CONSTRUCTION PLANS
FOR
PONDEROSA AT LORSON RANCH
FILING NO. 3
FINAL GRADING/EROSION CONTROL PLANS
WITH DETAILED GRADING PLAN (FOR INFORMATION ONLY)

PROJECT:
PONDEROSA AT LORSON RANCH FILING NO. 3
LITTLE DOGIE DR - OLD GLORY DR
COLORADO SPRINGS, COLORADO

COVER SHEET
FINAL GRADING
AND EROSION CONTROL PLANS

TYPICAL STREET/DRIVEWAY
SECTIONS AND
TYPICAL SECTIONS

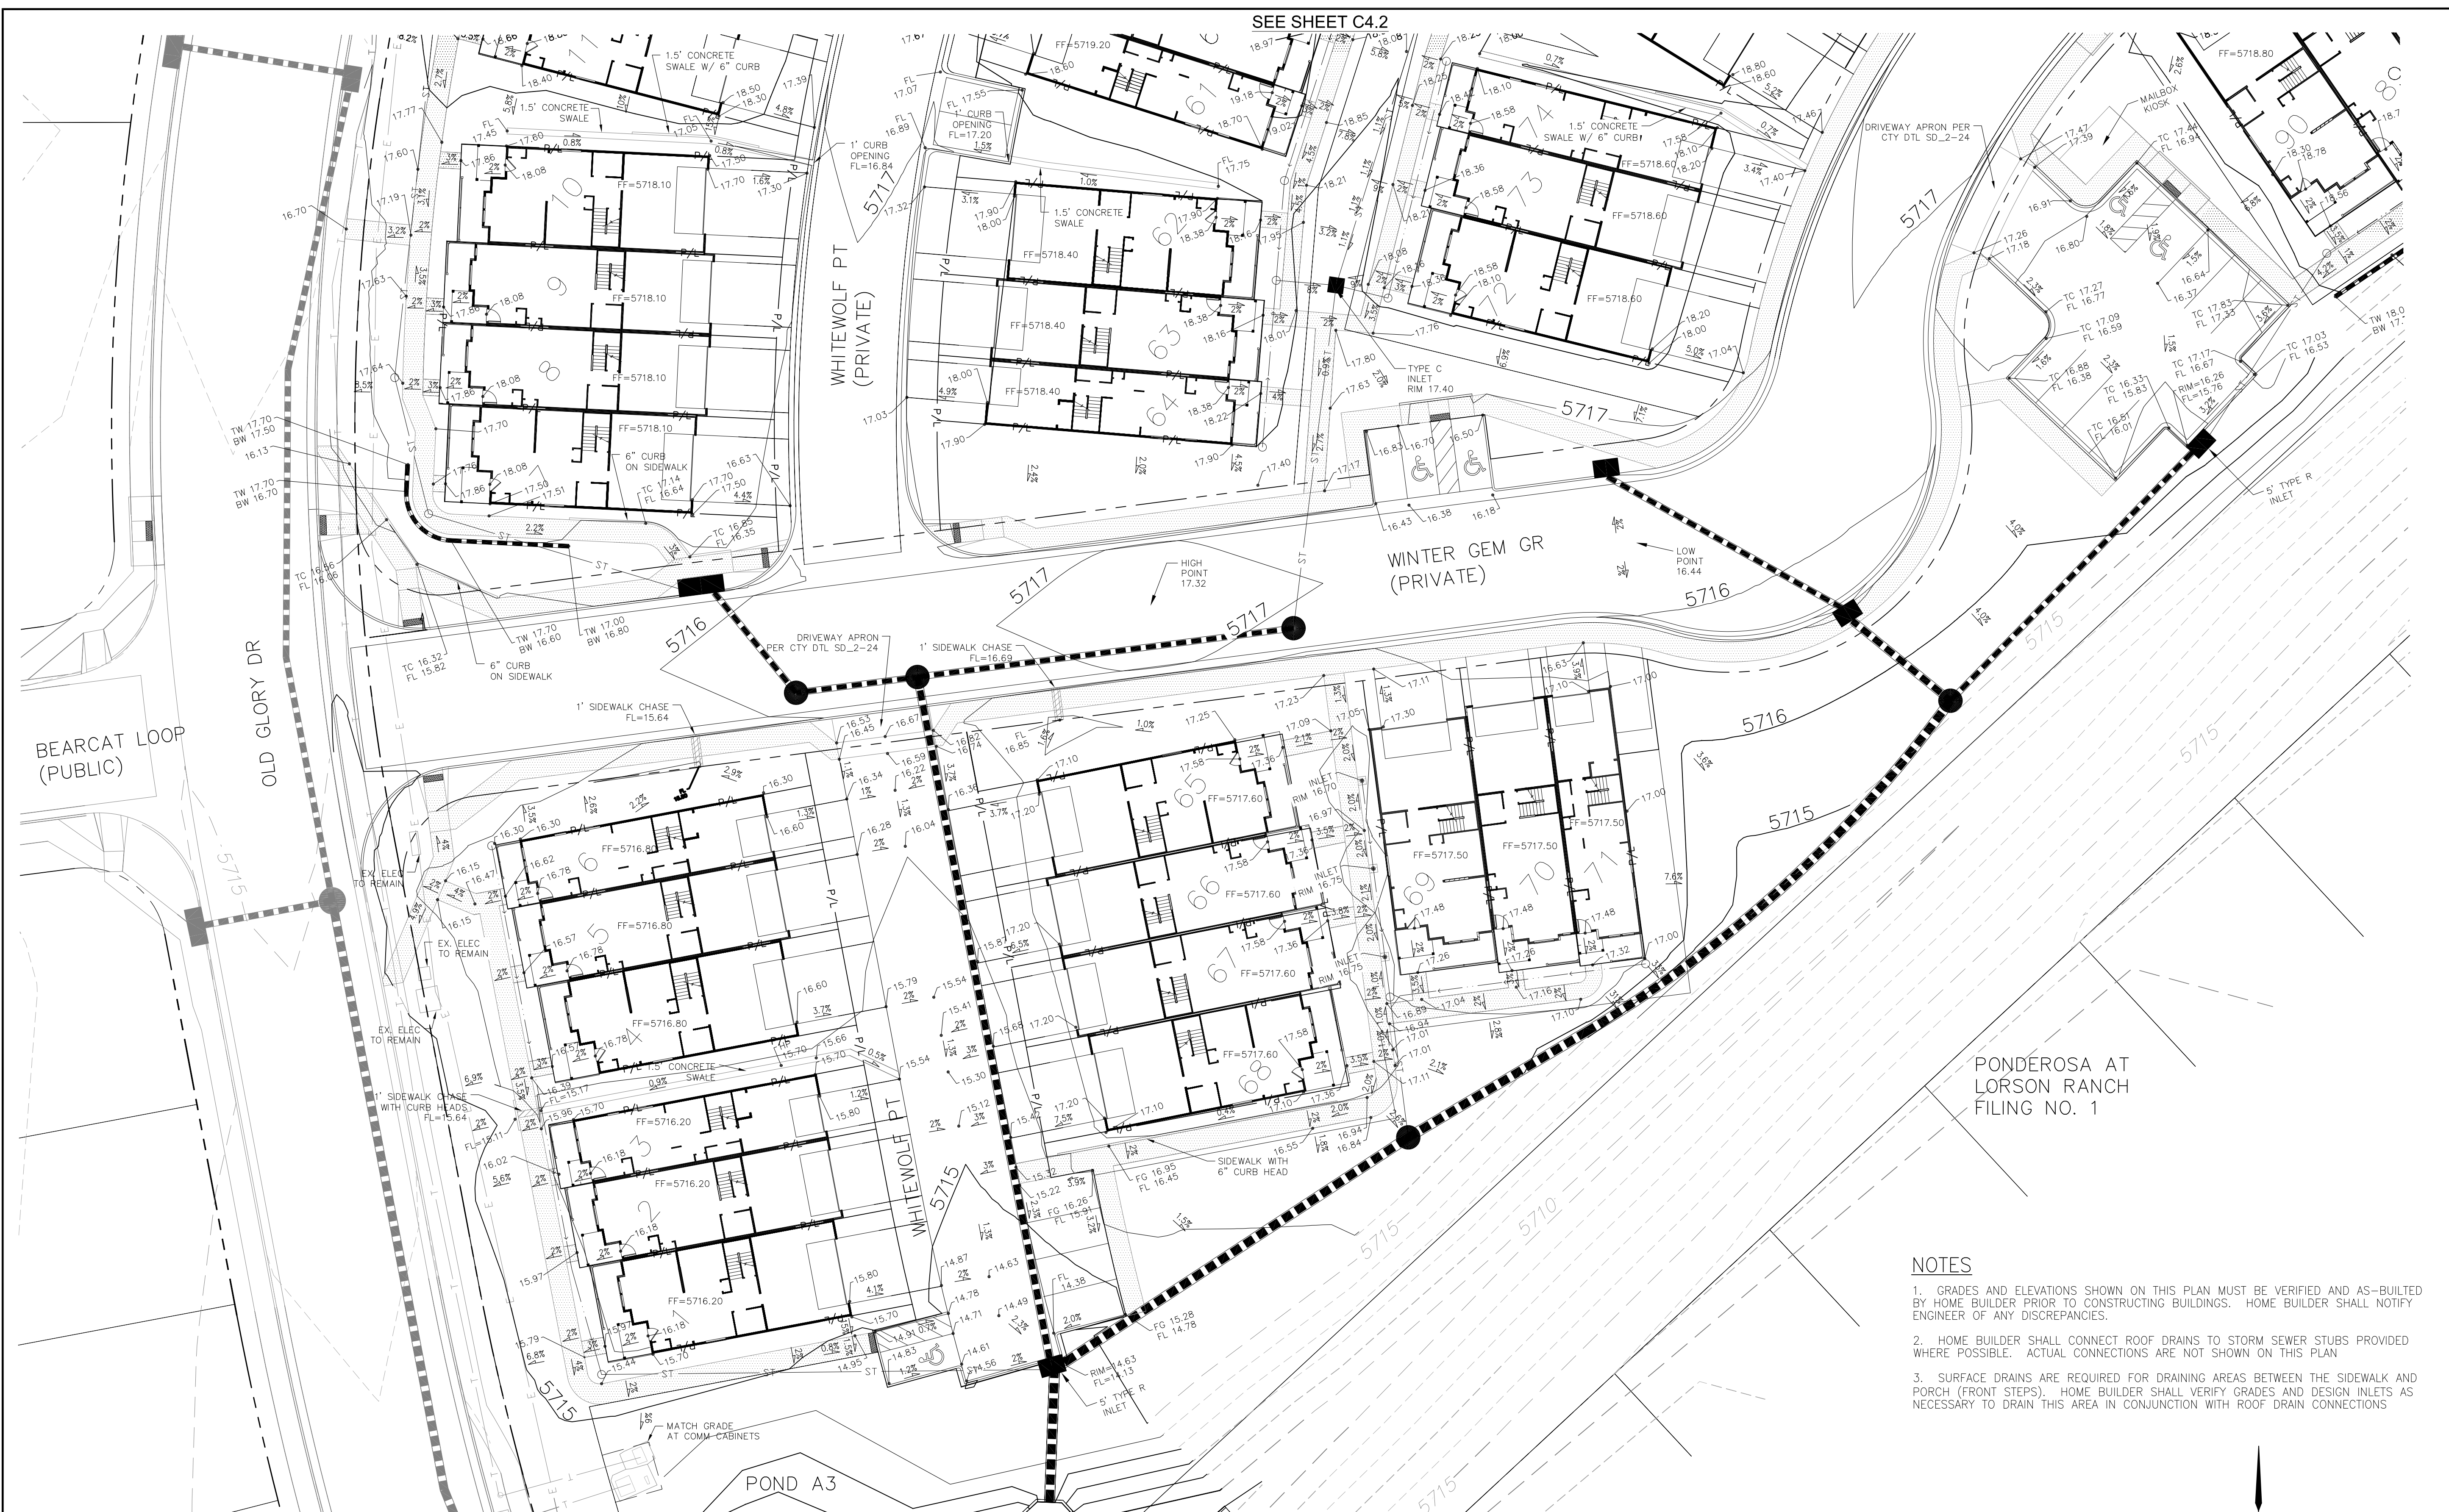
Remove the "For Information Only" throughout the plans
